Report for BCA Compliance

PROJECT NAME: Sikh Grammar School Sydney (Rouse Hill Campus) – SSDA Submission

DATE: 3 May 2019

01 PLAN- ELC and Boarding House
Level 0 (Ground)
Scale 1: 200

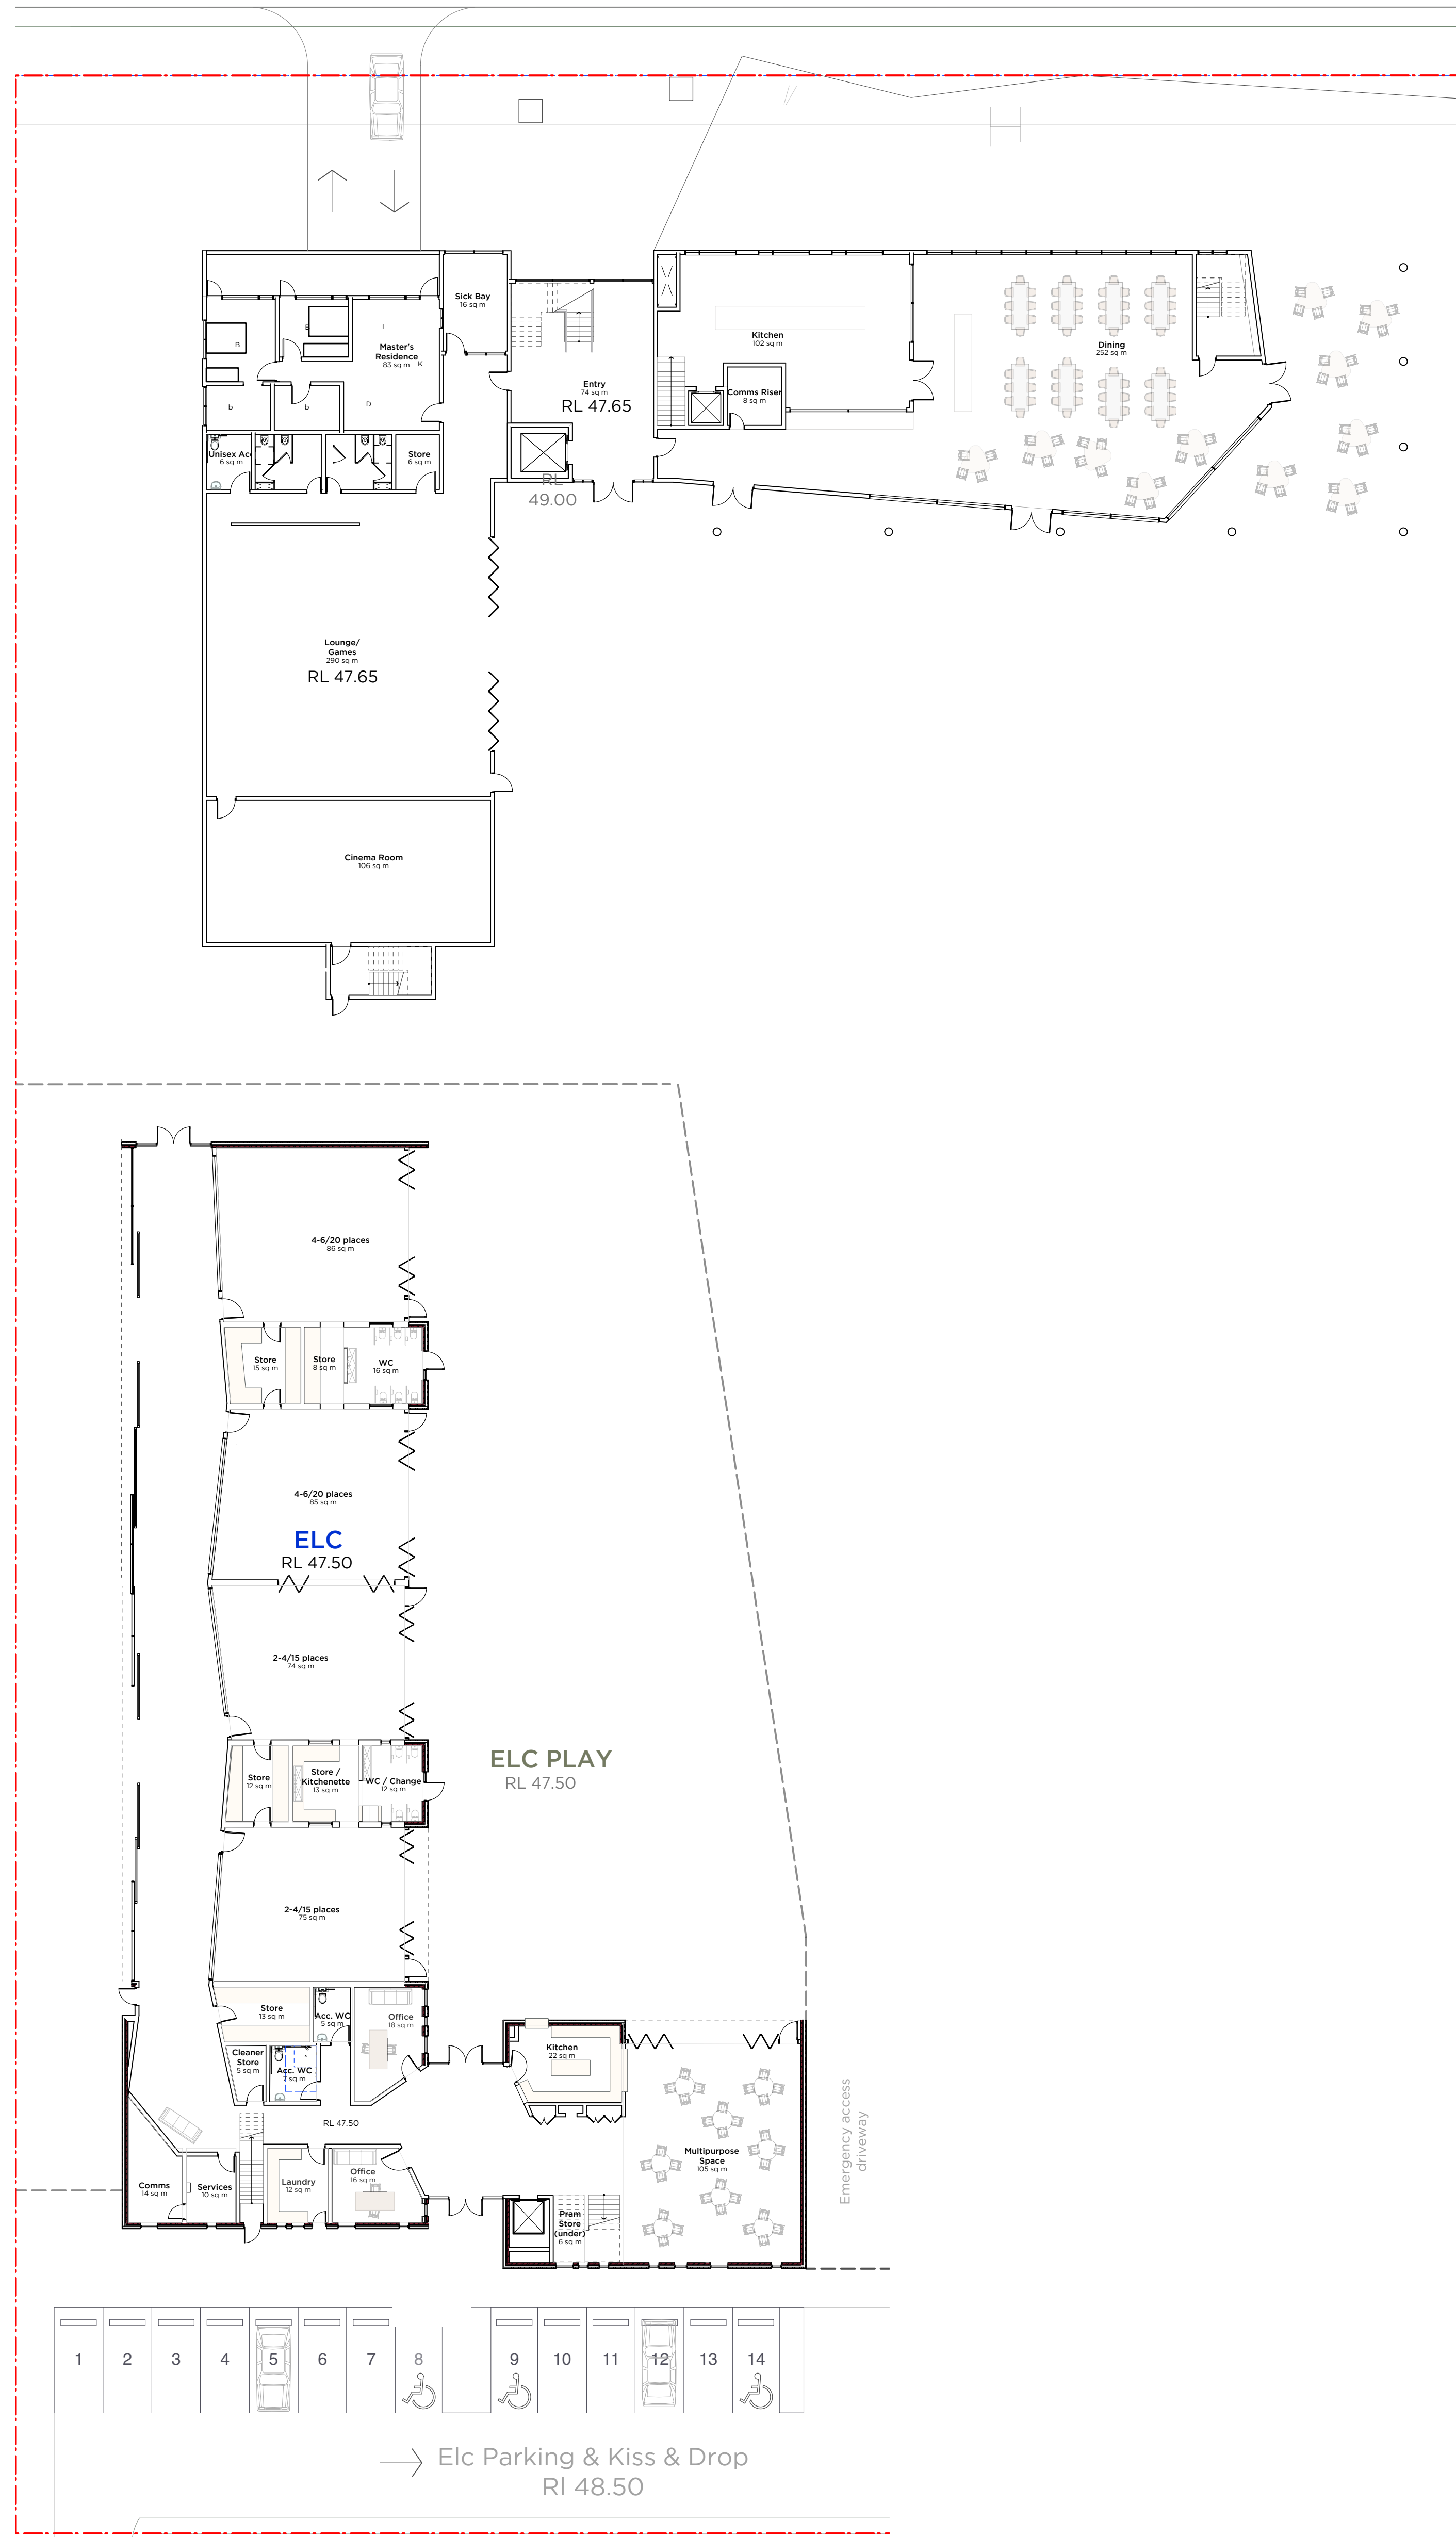
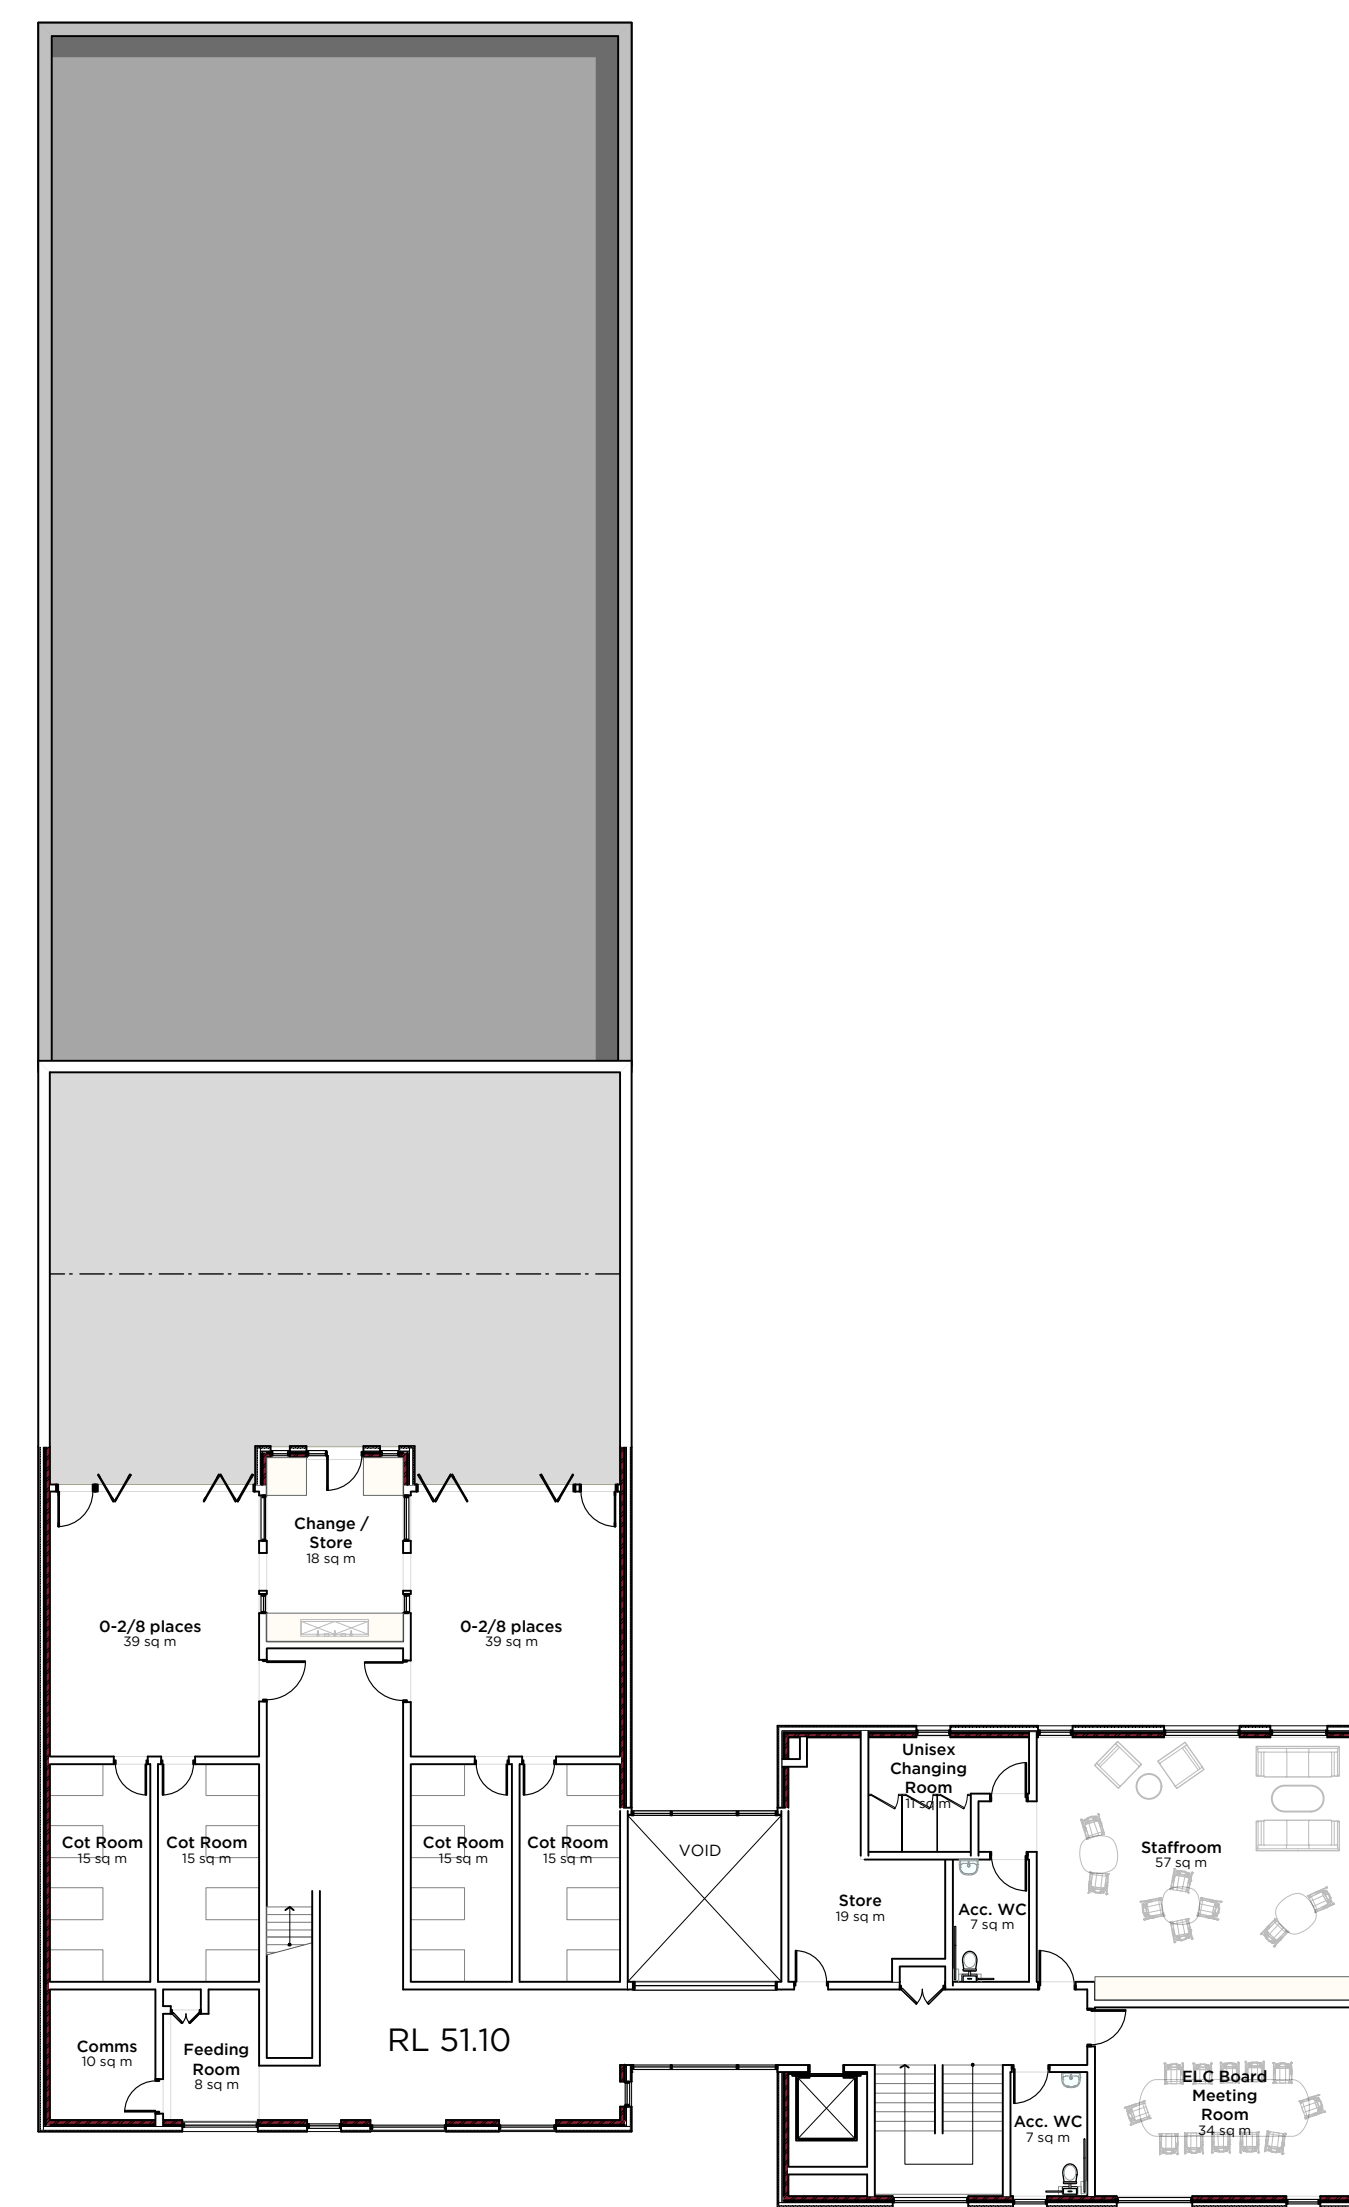
Boarding House – All levels except LG have not currently been illustrated with the fire separation (bounding construction) between the common areas, i.e. open lounge, kitchen, Games Room etc. The FRL is to be 60 minutes for non-loadbearing walls and 90 minutes for loadbearing. However the architect has confirmed that the design will be DTS. Further review at DD stage required.
